The Coal
Authority

PLANNING APPLICATION: 2023/62/91116/E

Erection of 67 dwellings at Land off Primrose Lane, Hightown, Liversedge

The Coal Authority Response: Substantive Concern

PRIMROSE LANE
 PROPOSED SITE LAYOUT

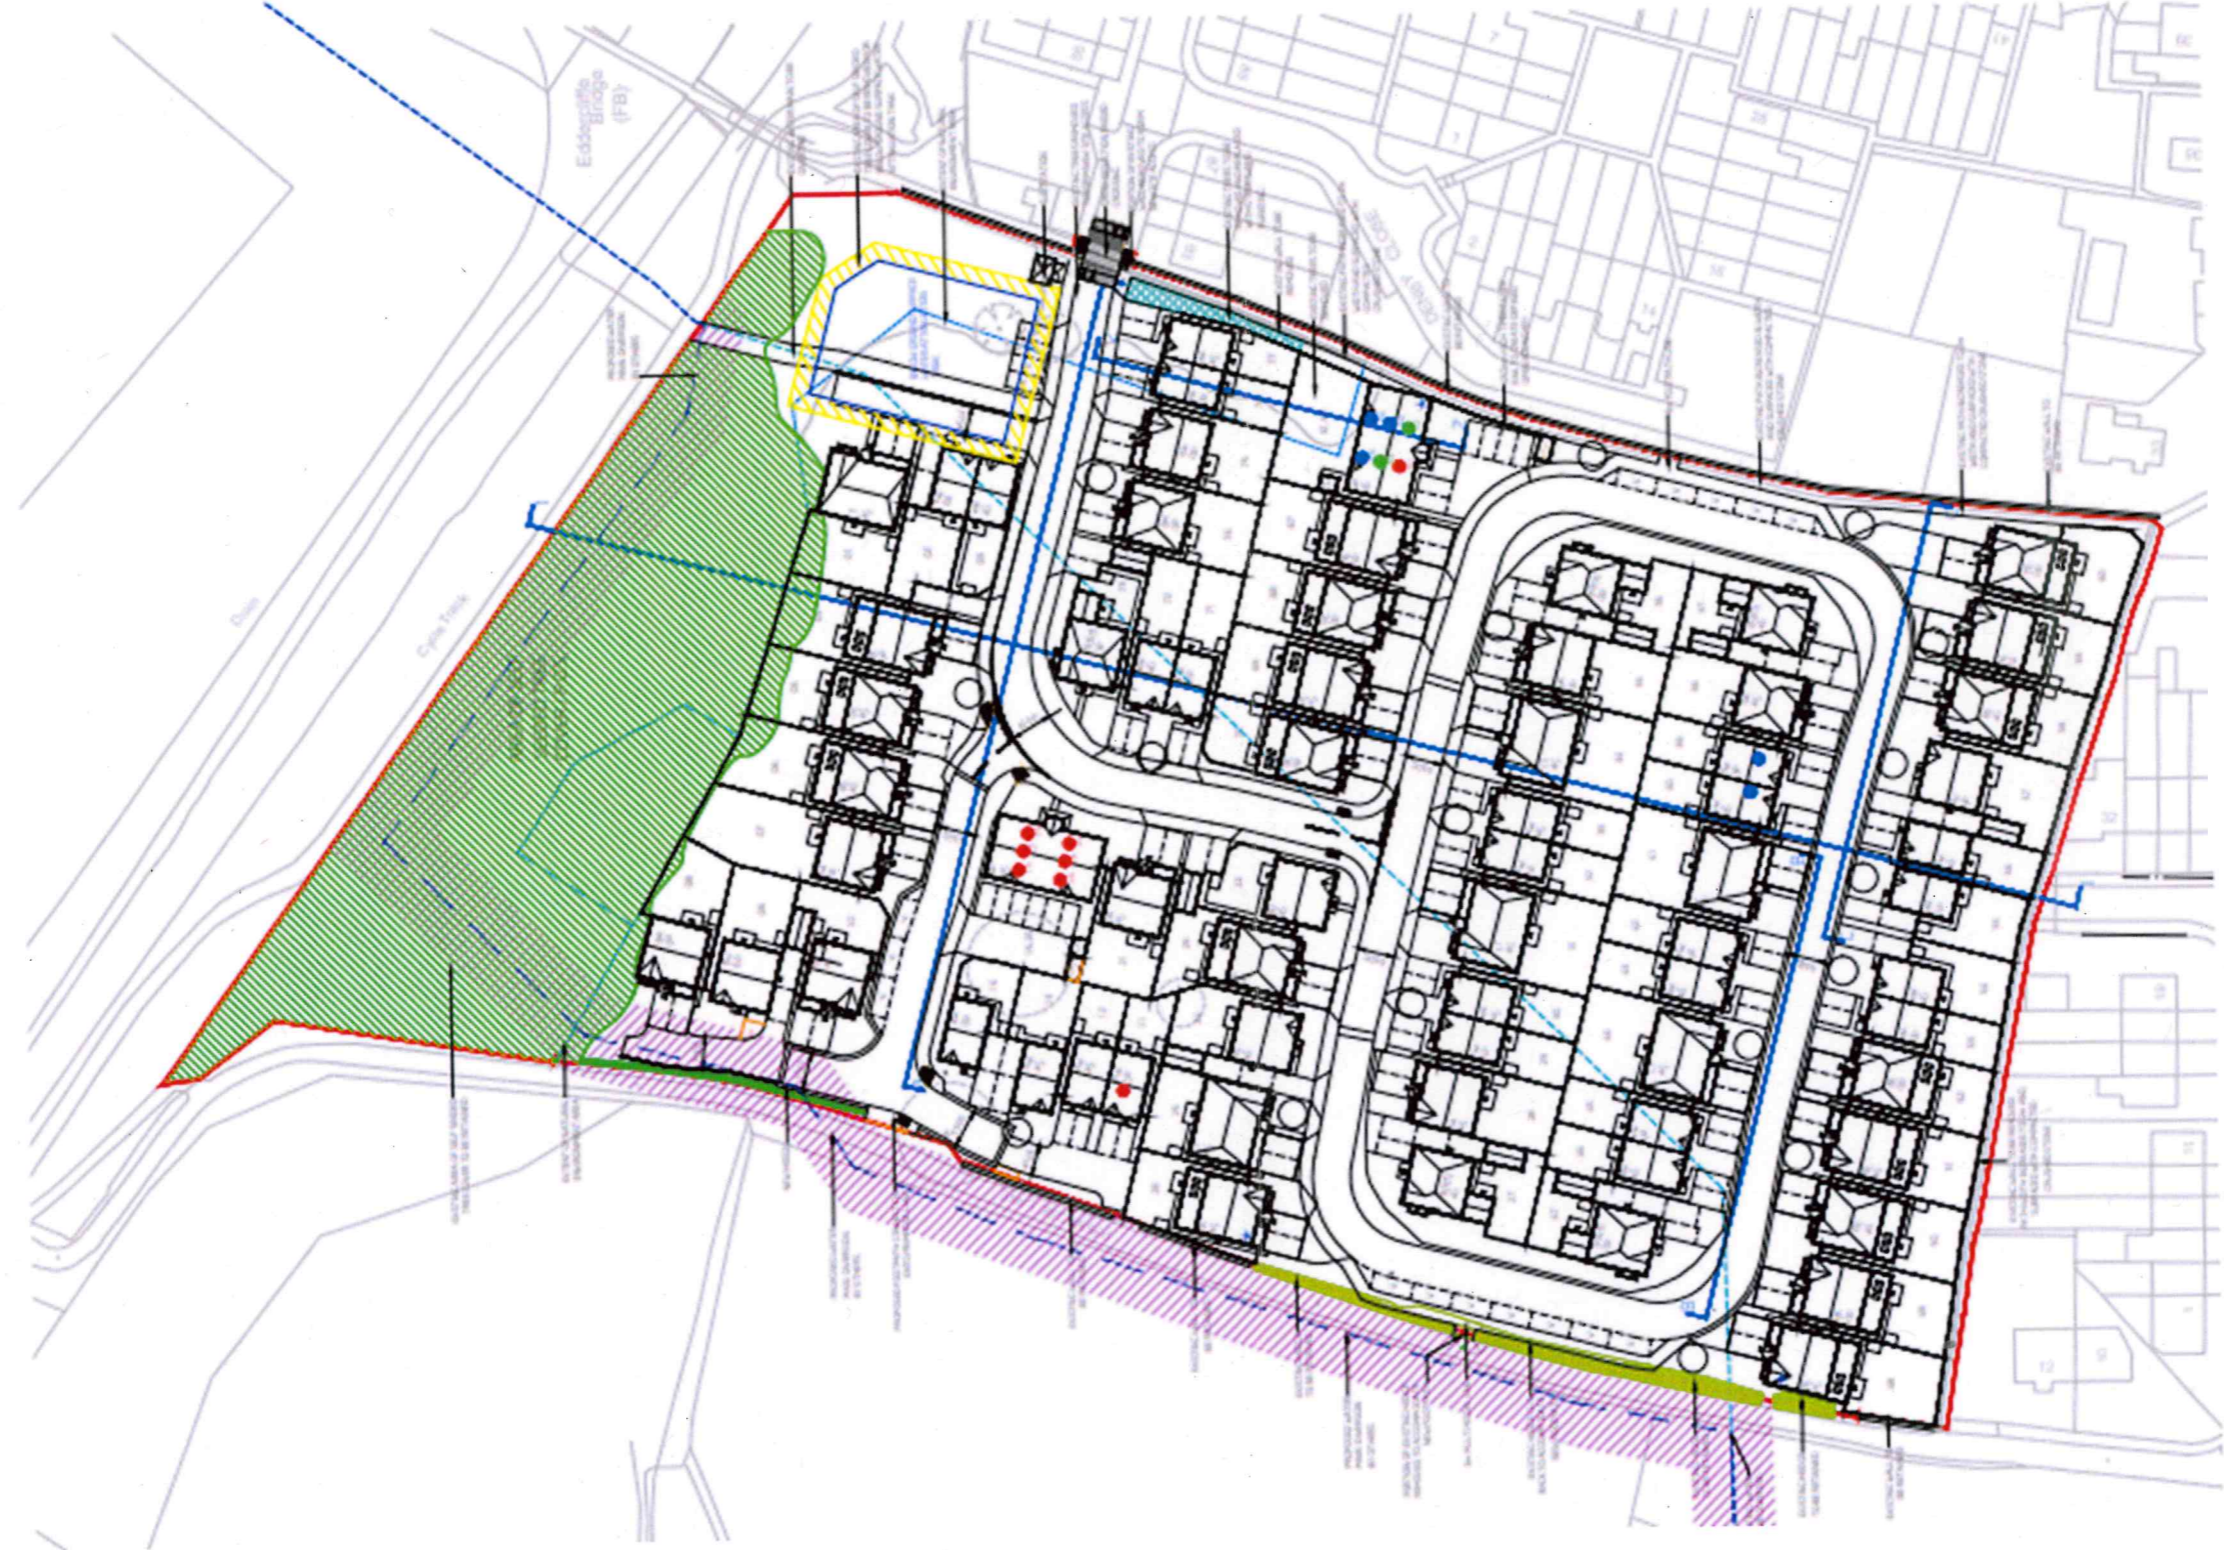
The Coal Authority's Planning & Development Team concurs with the report conclusion that intrusive investigations are necessary in order to establish the extent and characteristics of coal mining legacy affecting the site. However, we are concerned that the available information would suggest that the proposed layout of development has not been suitably informed by the presence of the mine shafts and their associated zones of influence, with buildings proposed close to or potentially over these features.

In order to demonstrate the acceptability of the proposed detailed development layout for which approval is being sought, we consider that intrusive investigations should be carried out prior to the determination of the application to locate and to establish the condition of all recorded mine shafts present, including establishing the adequacy of any past remedial treatment works carried out.

The information gained from these site investigations will enable the position of the shafts to be identified and their associated zone of influence to be calculated. This will allow any necessary revisions to be made to the site layout to ensure that the built development is sited in a manner which avoids the shafts and their zones of influence. These details should be clearly shown on a revised proposed Site Plan.

The supporting Coal Mining Risk Assessment does not demonstrate that the proposed detailed layout of development has been suitably informed by the presence of the mine entries recorded to be present within the site. It is the opinion of the Coal Authority's Planning & Development Team that the risk and uncertainty posed is such that further specialist investigation is required prior to the determination of the application to ensure that the LPA has sufficient information to be satisfied that the application site can be safely developed in the manner proposed.
